Ribble Valley Borough Council
Housing & Development Control

Application no: **3/2022/0361**

Address: **24 Oakdale Drive Whalley BB7 9FW**

Proposal: **Two storey side extension. Change rear conservatory roof. Drop kerb to rear and side. Fence to side of property.**

Scale 1 - 100 Proposed Plans

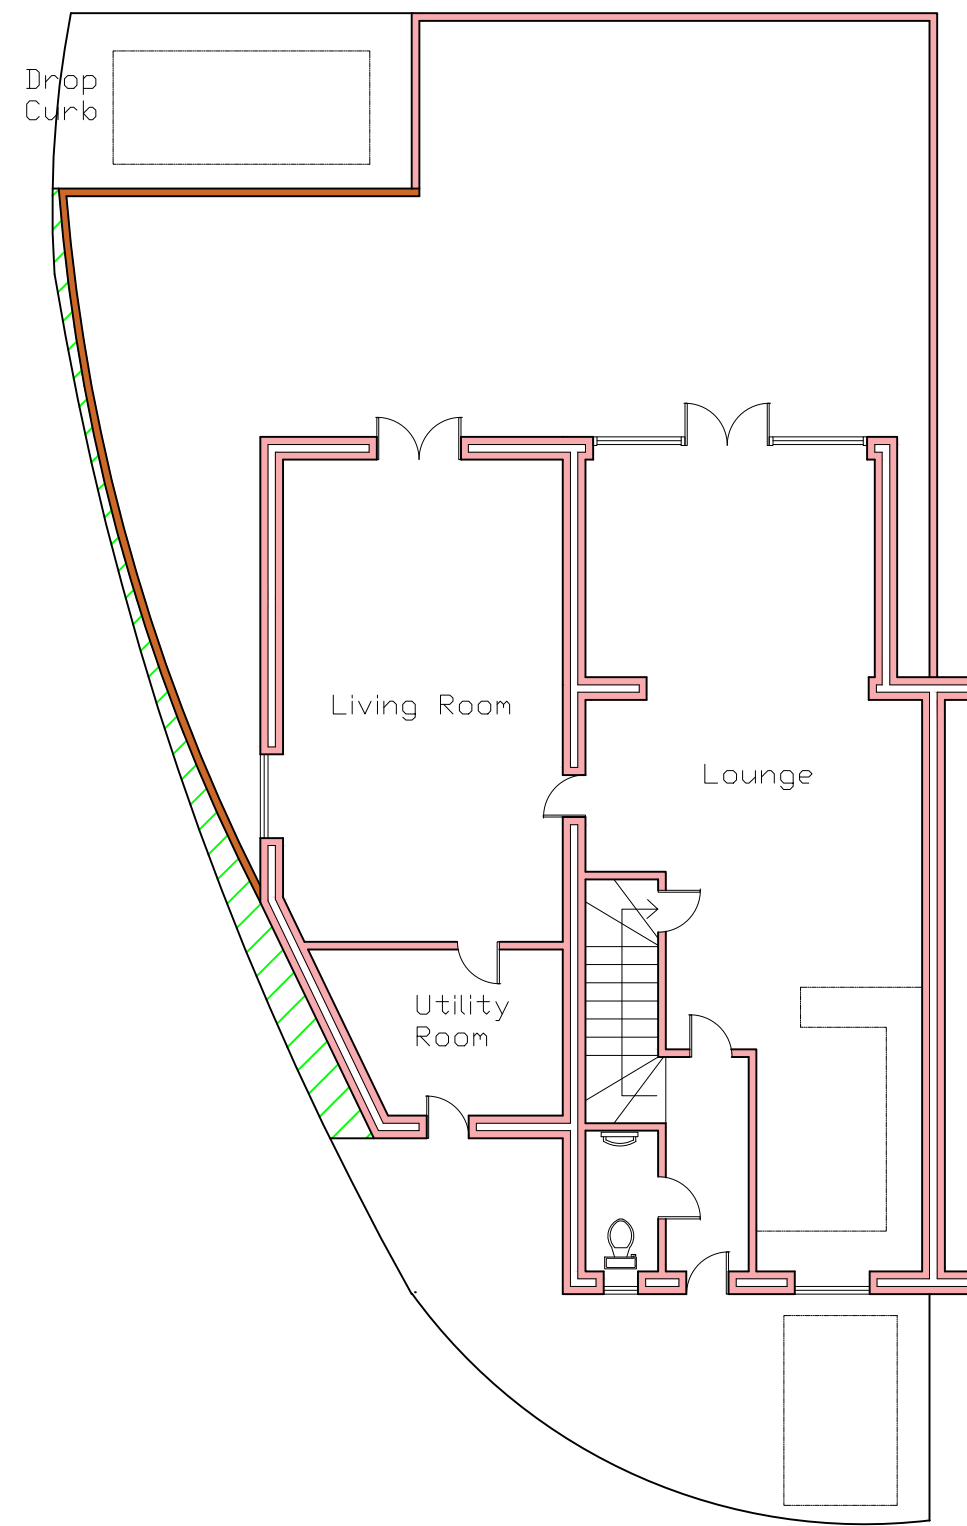
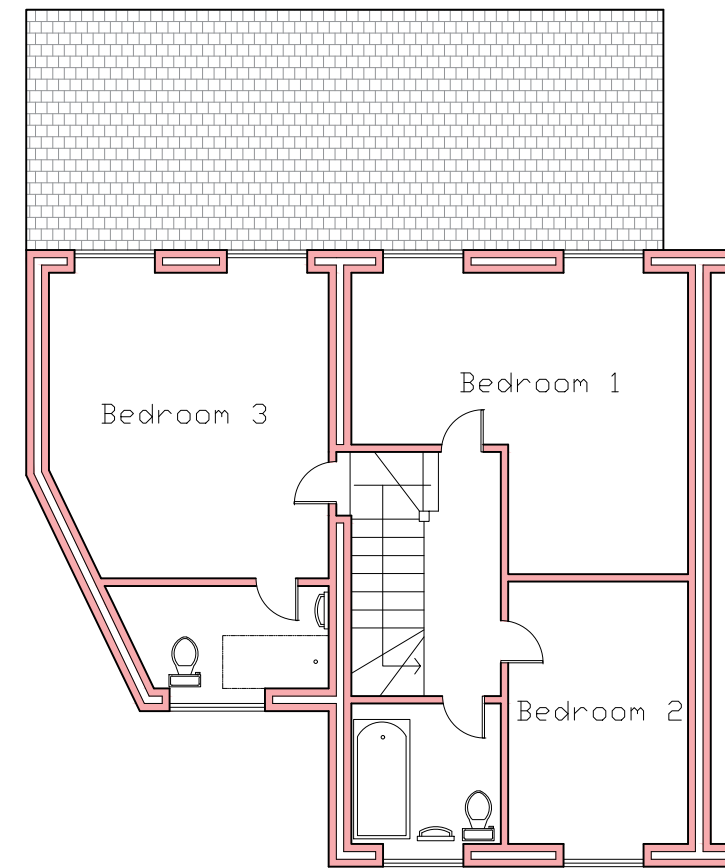
The LHA have reviewed Ribble Valley Home Extensions drawing titled "Proposed Plans," and are aware that the secondary access will be approximately 2.3m wide. However, this does not comply with the LHAs guidance which requires an access serving a single dwelling to be a minimum of 2.75m wide. Therefore, the LHA require the width to be amended on a revised plan.

On the revised plan, the drawing should also show that the access can achieve visibility splays of 2m x 25m in both directions to comply with the LHAs guidance for the speed of road.

Should the access not be able to achieve the minimum visibility, the LHA advise that the maximum visibility should instead be shown on the drawing. This is because if the shortfall in visibility is marginal, the LHA may accept the shortfall.

Furthermore, the LHA have reviewed the proposed parking space to the front of the dwelling. However, the LHA have reviewed the length of the space and are aware that the space is approximately 3m in length. This does not comply with the LHAs guidance for a car parking space which requires a space to be a minimum of 4.8m in length.

The LHA, as a result, advise that the space to the front is relocated to the rear of the site where the proposed access is located, and the existing access is stopped up. This is because there is limited space at the front to provide the minimum length for a car parking space.
